MEMORANDUM

RE: Geotechnical Review and Comment Response Memorandum

Creekside Village Residential Development

NGA File No. 1394722

PRELIMINARY ROAD, STORM DRAINAGE, AND GRADING PLAN

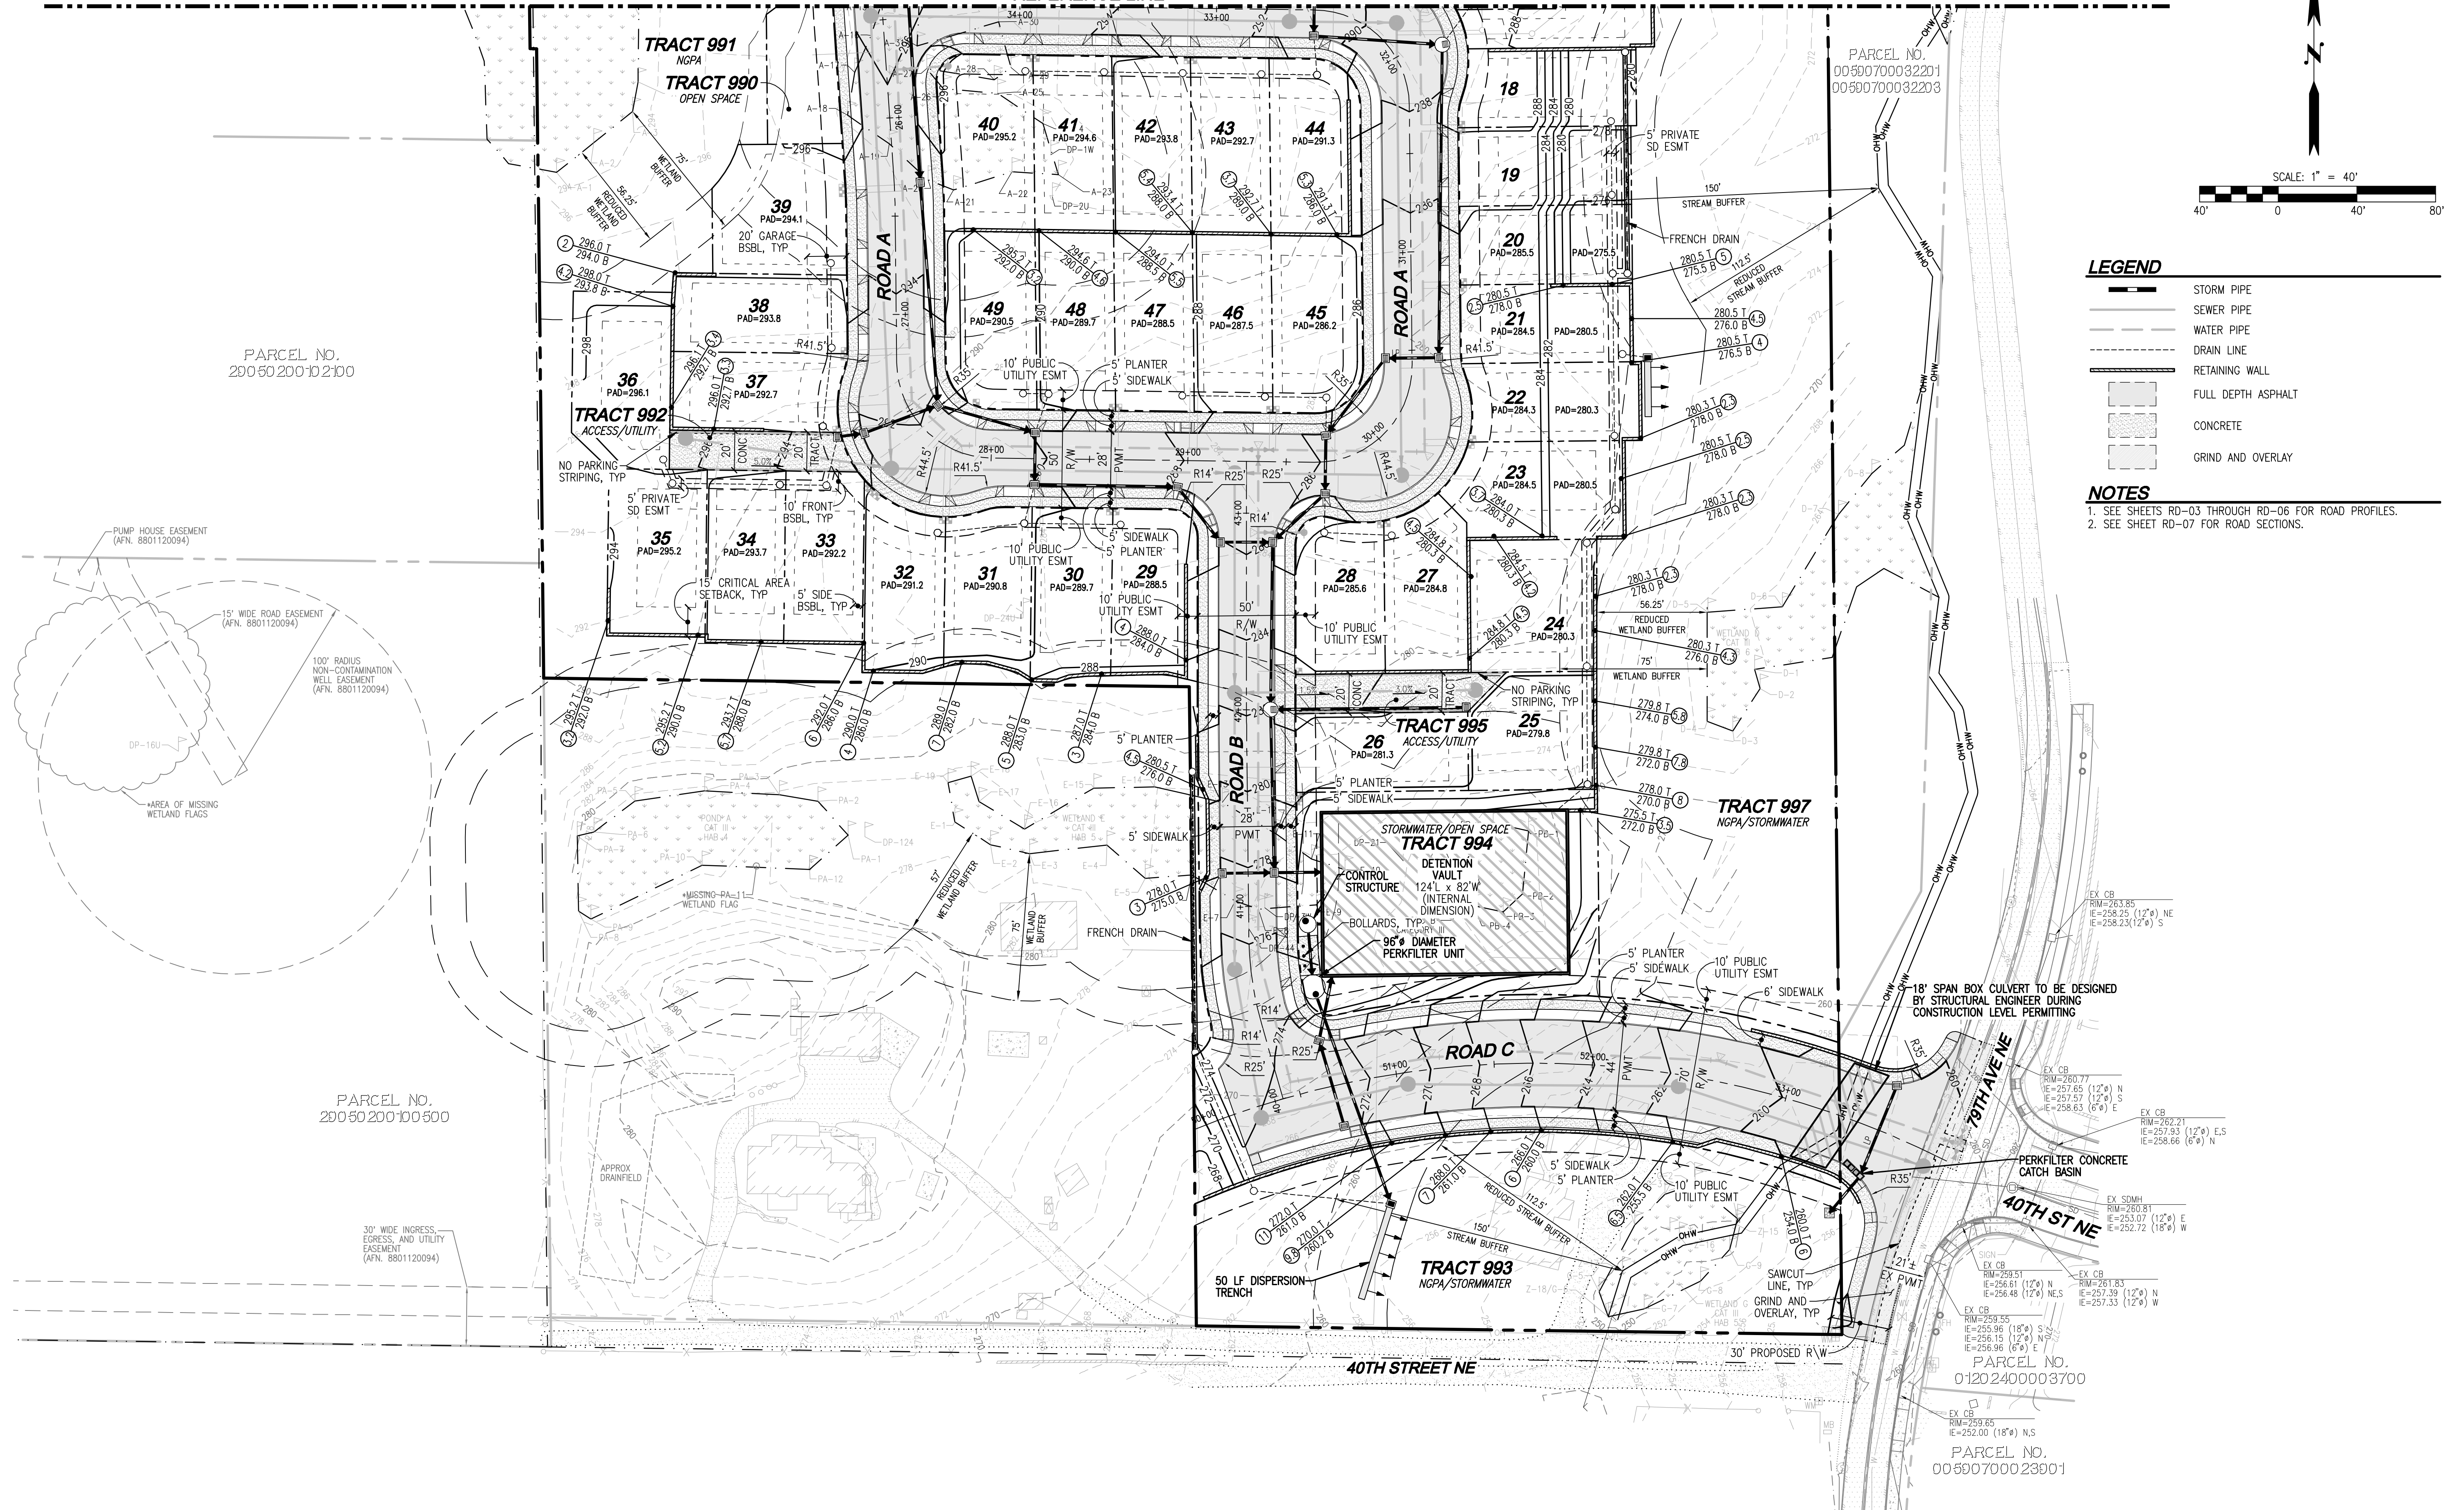
There was one additional comment below requesting a short letter stating walls specifically along Lots 21-25: "Additionally, please provide documentation from your qualified scientific specialist that the placement of walls on this project directly adjacent to the buffers will not have a negative impact on the hydrology of the critical areas and associated buffers."

RESPONSE 1: We understand there is a concern that placement of the walls and associated drains may have the potential to de-water the wetland/creek area. We reached out to LDC regarding more information regarding the wall drains, and requested a cross section of the proposed wall. Based on our review of the grading plans showing the contour lines of the slope onsite tapering to the wetland, as well as review of the cross-section, it appears the elevation of the base of the wall (and therefore the drainage zone) will still be above the elevation of the wetland and OHW of the creek by several feet, as the slope at the base of the proposed wall will continue down to the wetland to the east. Therefore, the placement of the wall drain will be above the wetland's OHW, and it is our opinion that the placement of the wall will not dewater the wetland or affect its hydrology.
